Planning

Our ref: MP 09_0081
File: S09/00664-1

61 - 79 HALL STREET, BONDI BEACH - MP 09_0081

SCHEDULE 1 – DEPARTMENT OF PLANNING KEY ISSUES

South East Elevation
1:400@A3

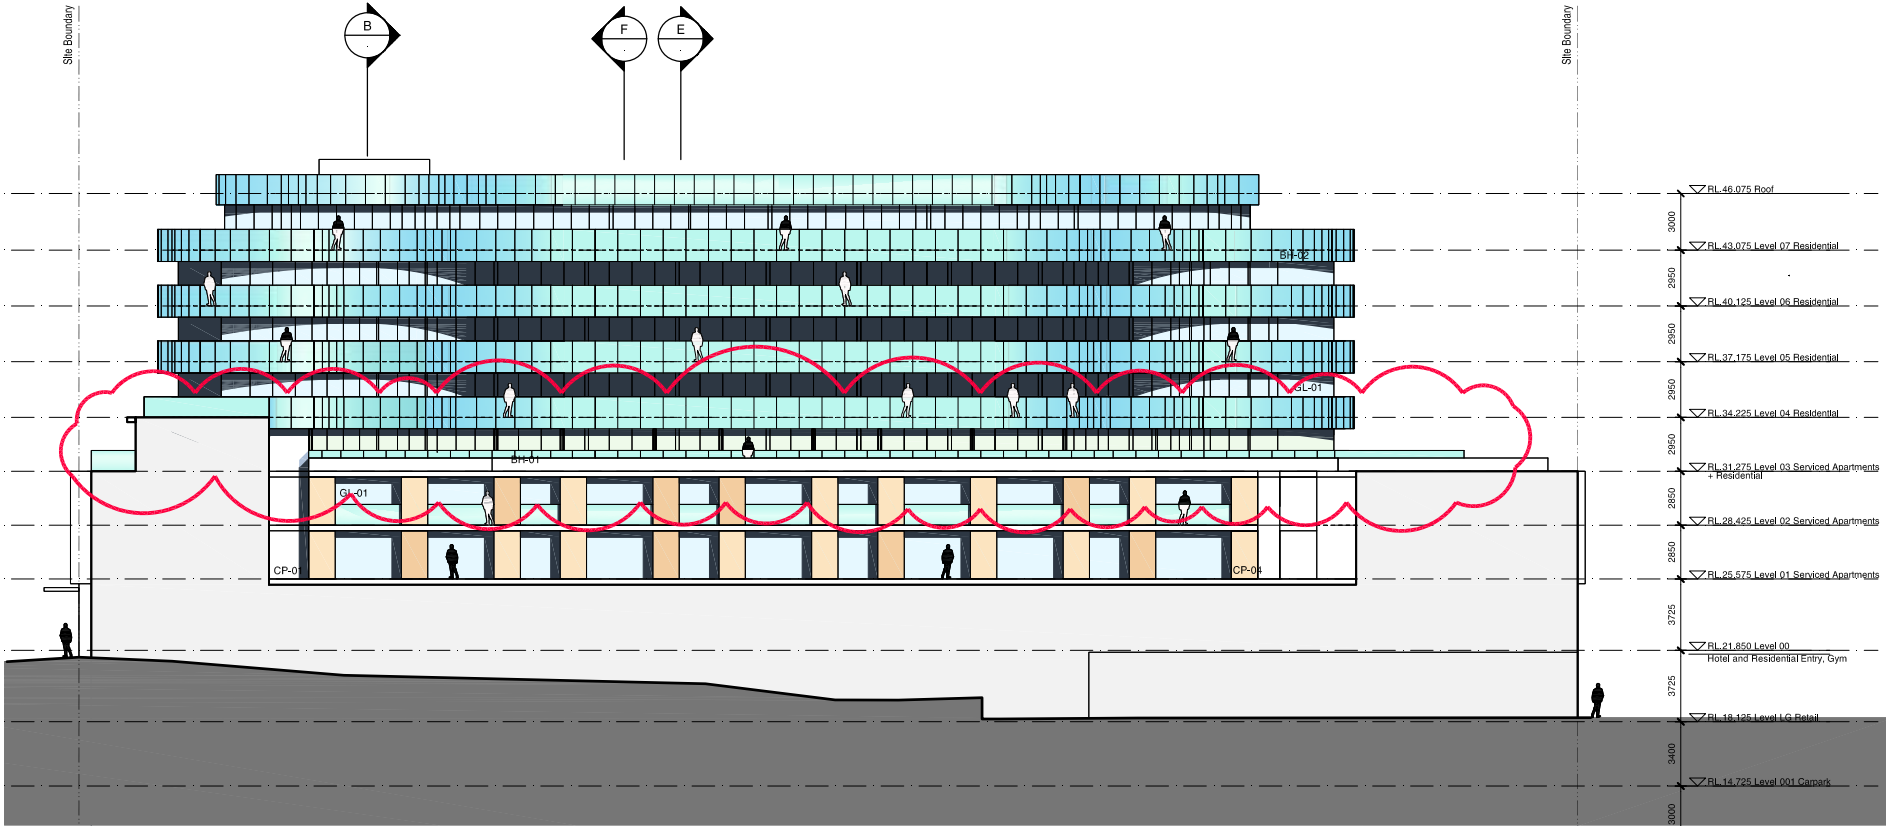
The proposed rear (O'Brien Street) and south-east side setbacks of both the podium (serviced apartments) and tower building above present a bulk and scale impact on the local urban context.

Further analysis of these setbacks is required which may include a consideration of different options for achieving greater podium and tower setbacks to O'Brien Street and the adjoining residential zone to the south east.

Level 07 Plan - Roof Plant shown blue

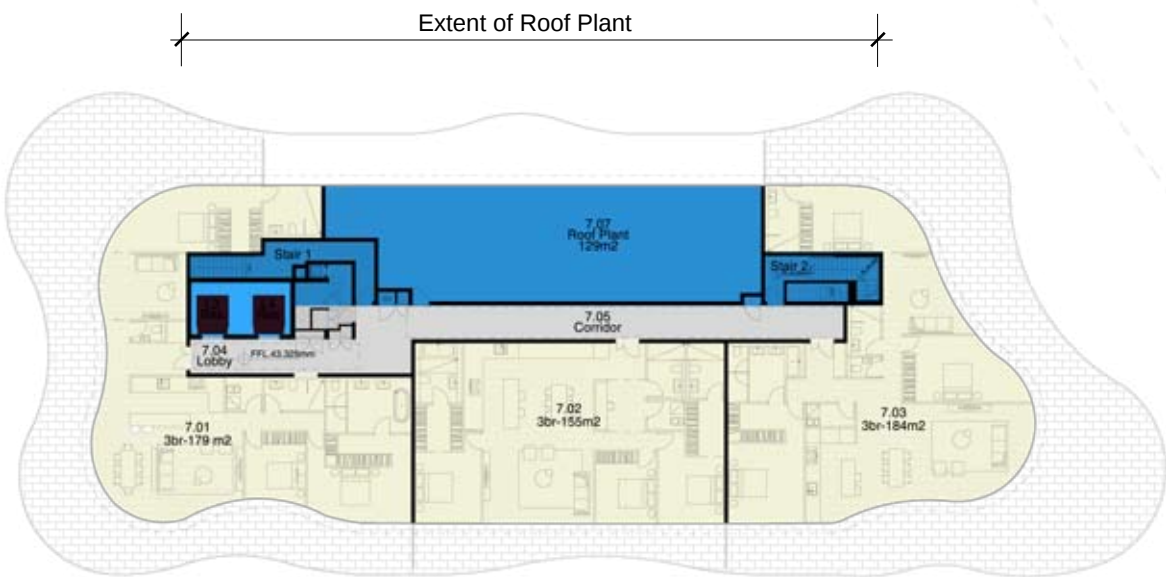
Further justification should be provided (including identification of impacts) to support the additional storey above the existing Hakoah Club building. Options should be prepared considering the redistribution of the floorspace in the additional storey across other areas of the site.
